Ramblers – Written Representation 16841

I am representing the Stamford, Bourne and The Deepings Ramblers' Group as an Interested Party. This is a group of around 100 members who regularly walk around the network of public footpaths and rights of way in the locality. This Group is also joined regularly by Ramblers from other Ramblers' Groups for walks in the area. This submission summarises concerns around the impact this project poses to Ramblers and may indeed apply to the many other walkers using the impacted paths.

DRAWING TITLE
Figure 6.11: Green Infrastructure Strategy Plan

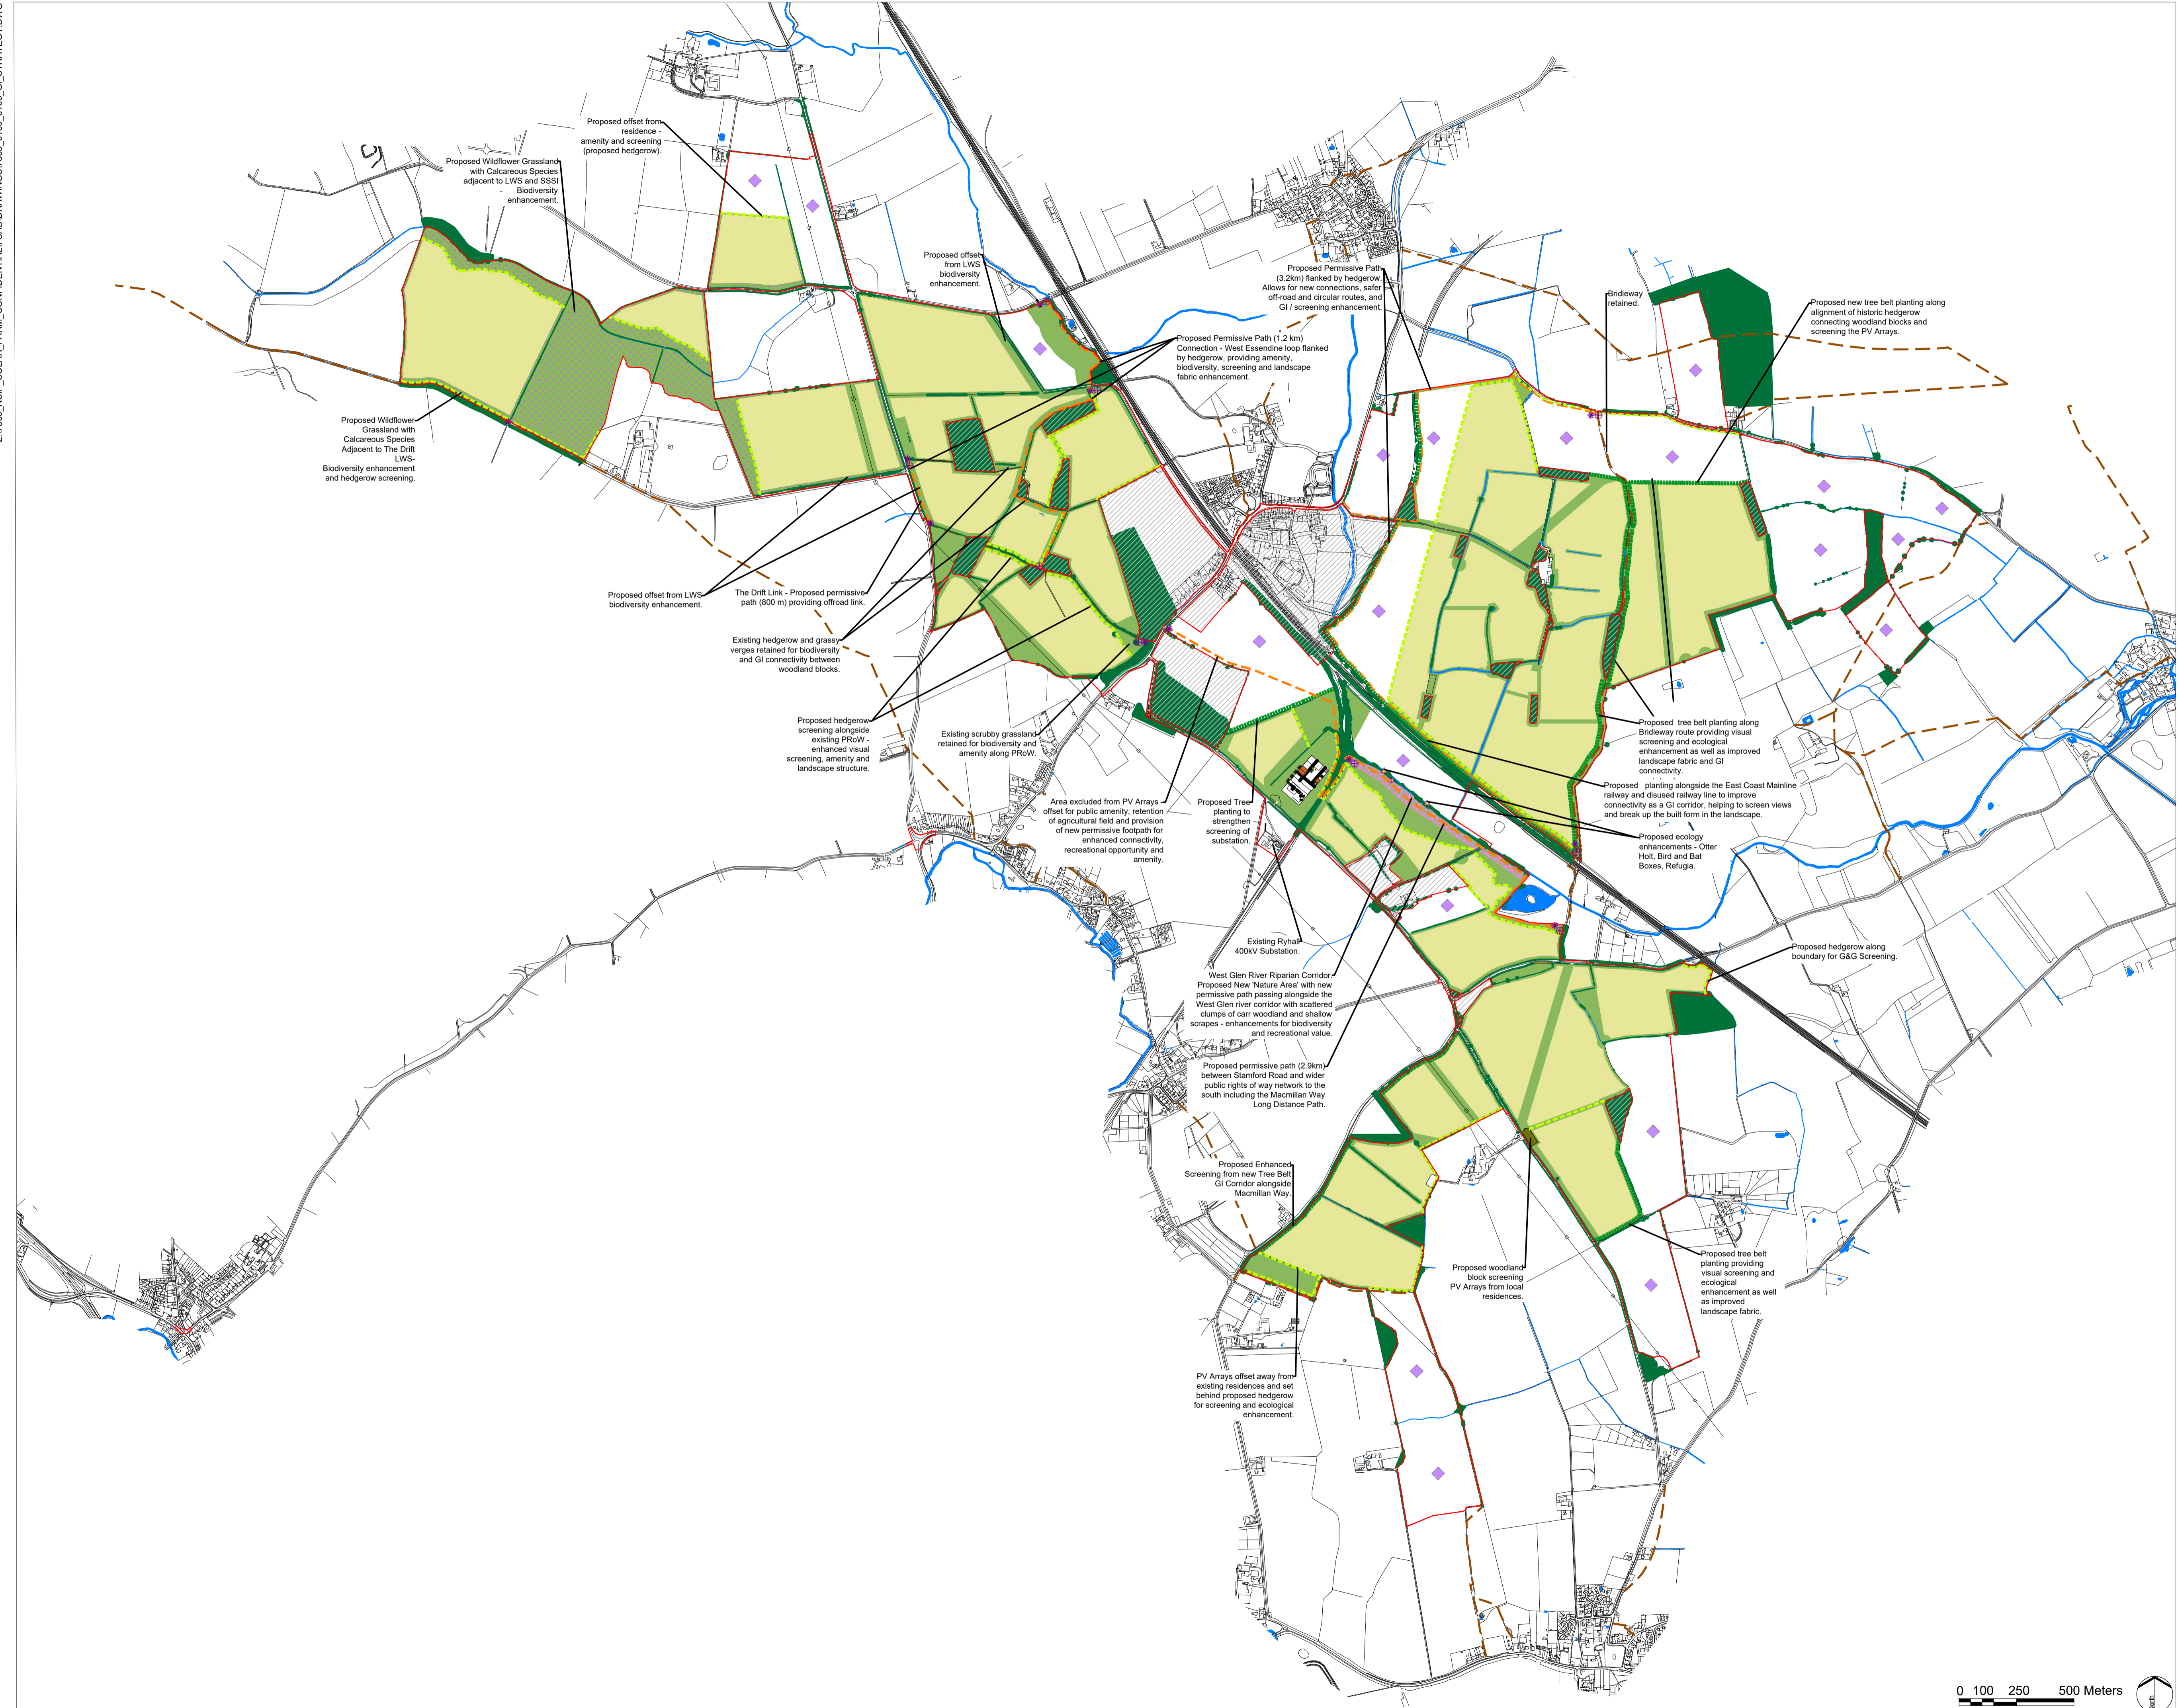
The section which goes from the Carlby to Greatford road, starting at grid ref 057134 and runs down to and along the East Coast Mainline railway line, before meeting up with BR AW1/1, offers a circular route but its real purpose appears to offer improved connectivity as a G1 corridor. Would our walkers want to walk along a screened path for three miles with a half-mile section along the busy, noisy, East Coast Mainline railway track? No. There would be trees to ‘screen views of panels and break up the built form of the landscape,’ says the Applicant, but this would still not be attractive option to Ramblers.

4. The lower section of this proposed permissive path

The section on the south side of the East Coast Mainline railway line has proposed ‘otter, bat, and holt

boxes'. Why have they proposed them near the railway line? This path would do a loop down to the new 13-metre-high substation. The noise from this would not endear ramblers, nor indeed wildlife, to go anywhere near it.

7. The 1.2km proposed permissive path between fields 7, past 2 and 13

The section of this path that joins up with the bridleway mentioned in my point above would offer a short route between Carlby and Essendine but it is very close to the East Coast Mainline in field 7, so how many people would enjoy using this route? Maybe dog walkers as 'needs must' but not Ramblers.
